SWPPP COMPLIANCE INSPECTION REPORT

Date of Inspection	Thursday, February 17, 2022
Project	7200 Bluewater NW
Location	SW corner of Airport Rd and Bluewater Rd

NPDES #	NMR 1003UT and NMR 1003WM
Permit Type	Construction General Permit and LEW
Inspection Type	SWPPP Compliance Inspection- 14 day or >.25"

ENGINEER'S SEAL RONALD R. BOHANNAN P.E. #7868	7200 BLUEWATER RD ALBUQUERQUE, NM	DRAWN BY pm
		DATE 8-4-21
	EROSION CONTROL PLAN	DRAWING 2020056-SWPPP
	TERRA WEST, LLC 5571 MIDWAY PARK PL NE ALBUQUERQUE, NEW MEXICO 87109 (505) 858-3100 www.tierrawestllc.com	SHEET # SW-1 JOB # 2020056

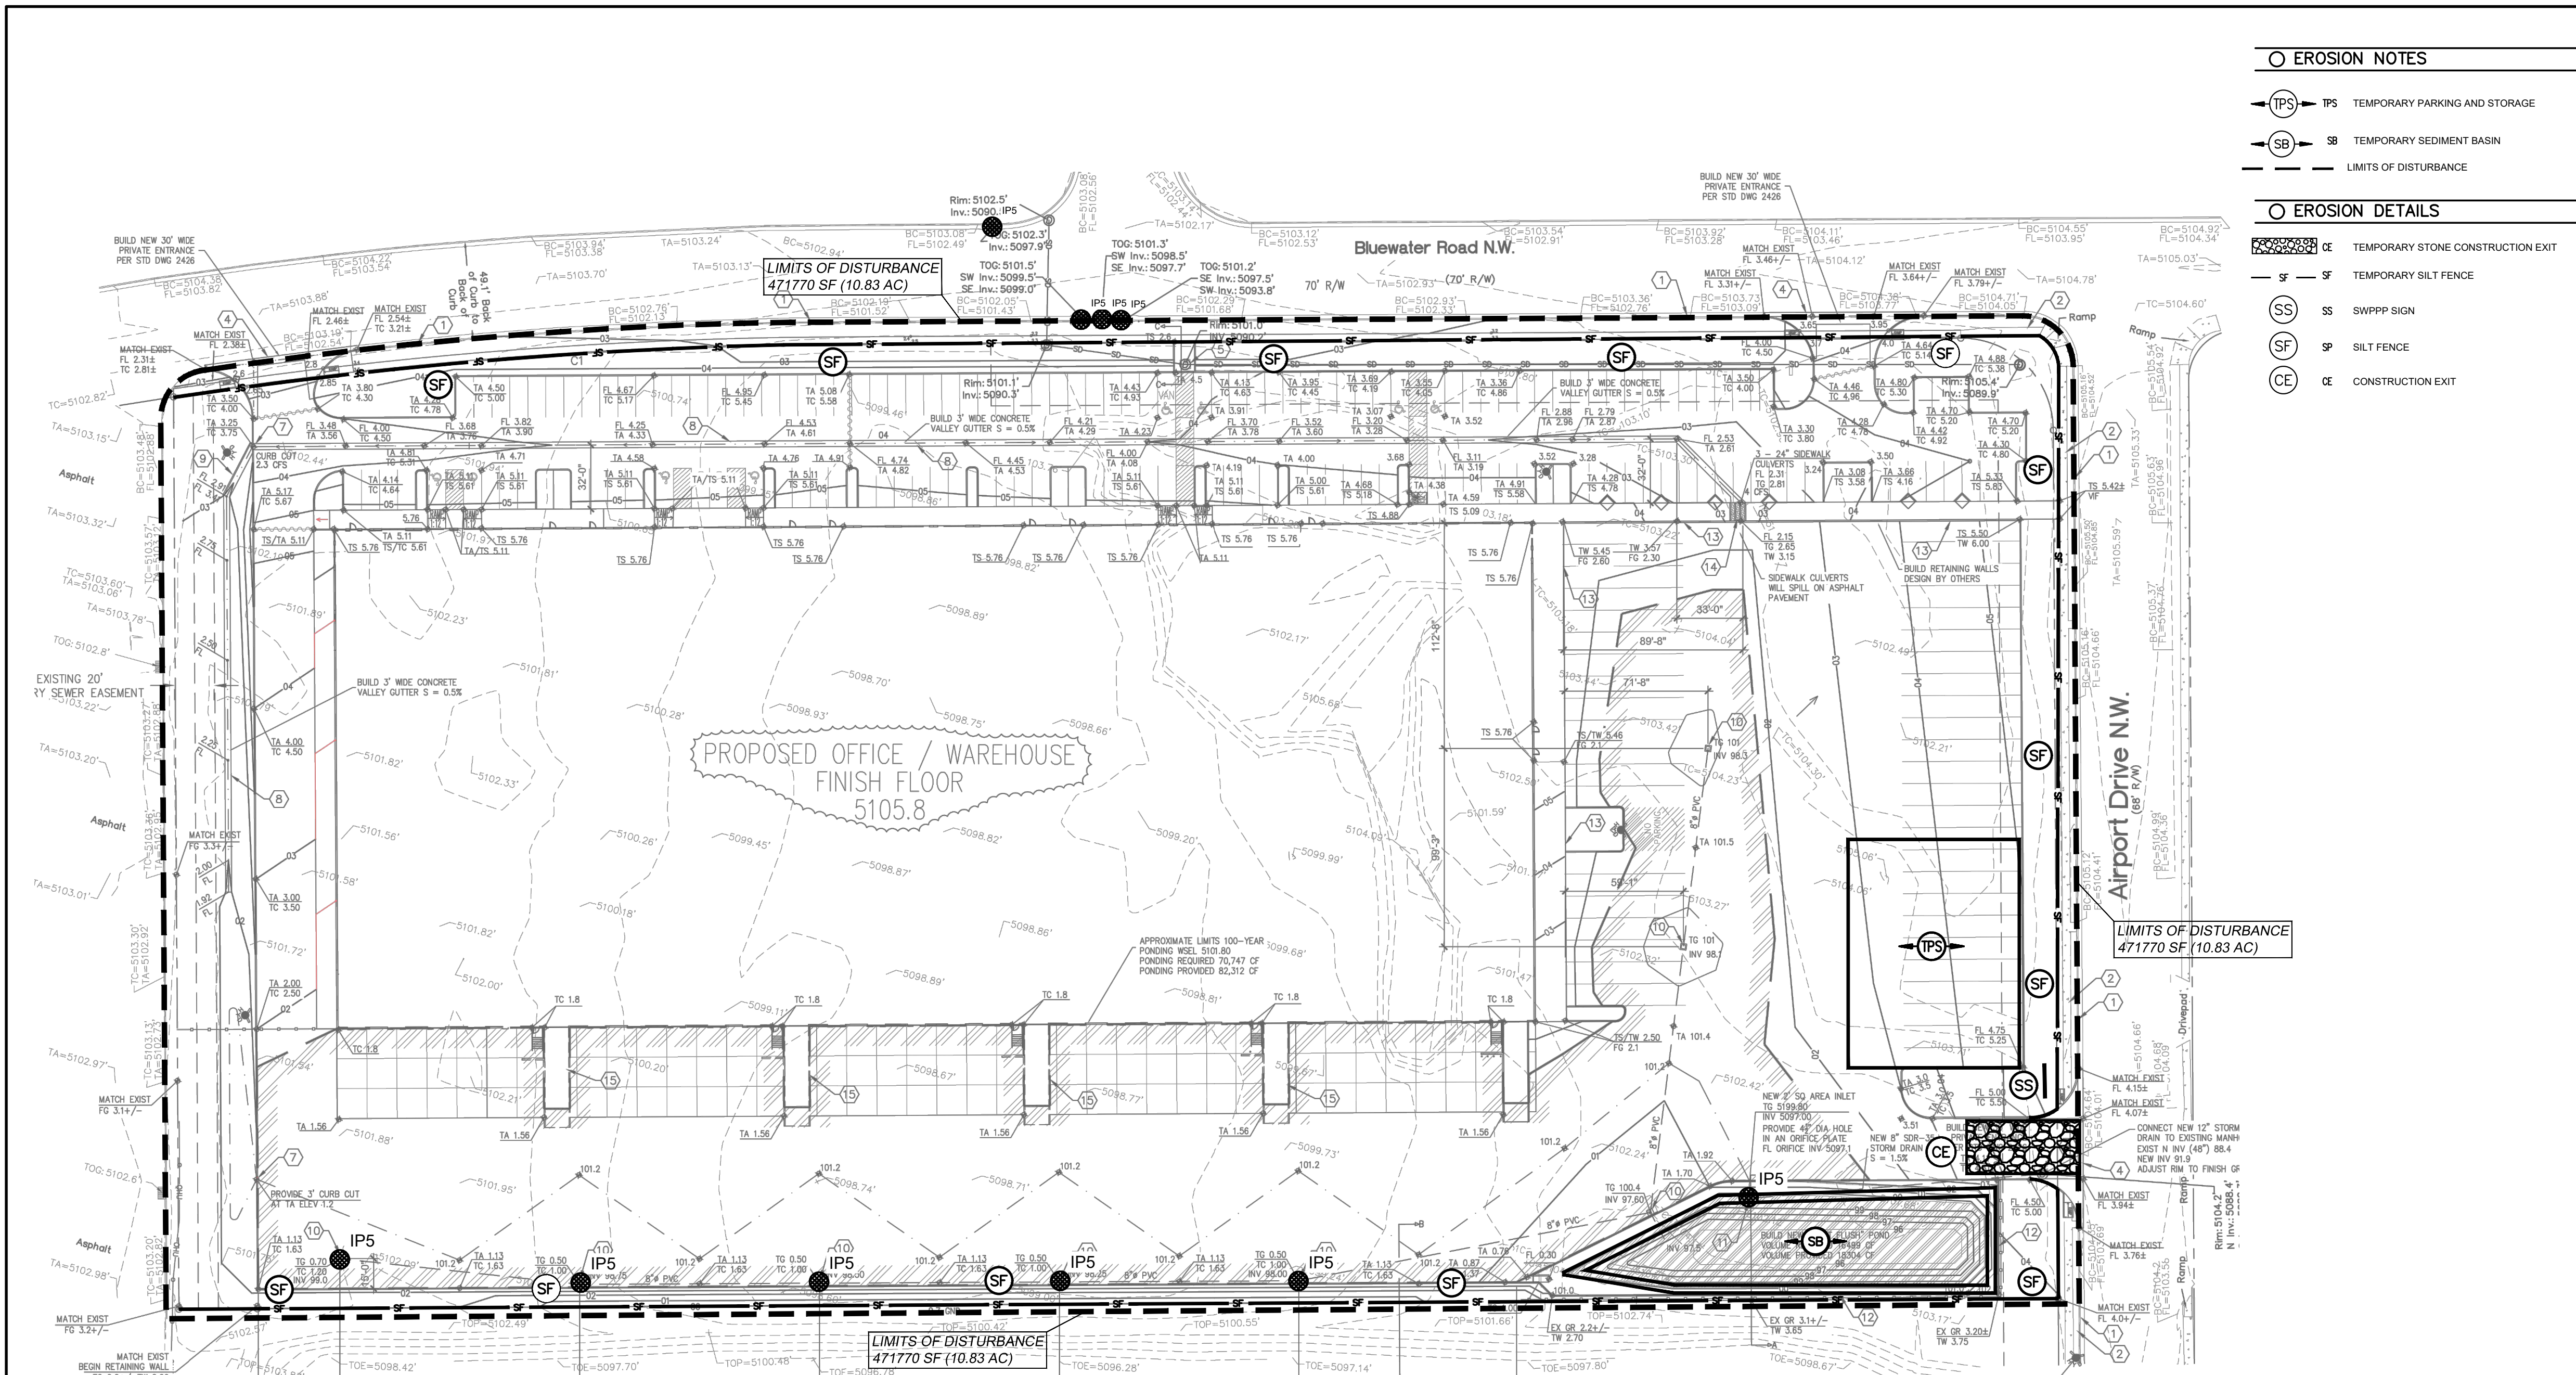
SWPPP Item	Yes/No/NA	Action Required	Notes:
Is the SWPPP Notice properly posted with correct information?	Yes	None	None
Are the Limits of Disturbance properly protected?	No	Complete silt fencing installation	SWPPP Contractor has started re-installation of silt fencing. Key silt fencing into subgrade.
Are all Natural Resources or boundary with the Waters of The United States properly protected with barriers or BMP's?	N/A	None	None
Are Construction Exits properly controlling sediment track out from the site?	Yes	None	Primary entrance is in good condition. Other entrances are closed to traffic as completed
Are all Discharge Points and Offsite Flows properly controlled?	Yes	None	None
Are all Channels, Spillways or Emergency Overflows protected?	N/A	N/A	N/A
Are Inlets and Water Quality Devices properly protected from sediment?	Yes	None	Inlet protection is adequate
Are there any stockpiles inactive for 14 days or more that require Temporary or Permanent Stabilization installed?	No	None	Stockpile is in use for foundation fill

Do all steep slopes have proper base and intermediate controls in place?	N/A	N/A	N/A
Are Wash Out Facilities available and clearly marked ?	No	Re-post signage at wash out, clean up overflow	Dispose of concrete wash when capacity is reached

Control	Location	Issue	Maintenance or Corrective Action?
Silt Fencing	Perimeter	Removed for Landscaping	Installation in progress
Concrete Wash Out	East side of site	Clean up residue and post wash out signage	Maintainance

Key silt fencing into sub grade, Re-post concrete wash out signage.

Concrete Wash requires maintenance and signage

Key silt fencing into subgrade

Landscaping/Silt Fencing in Progress
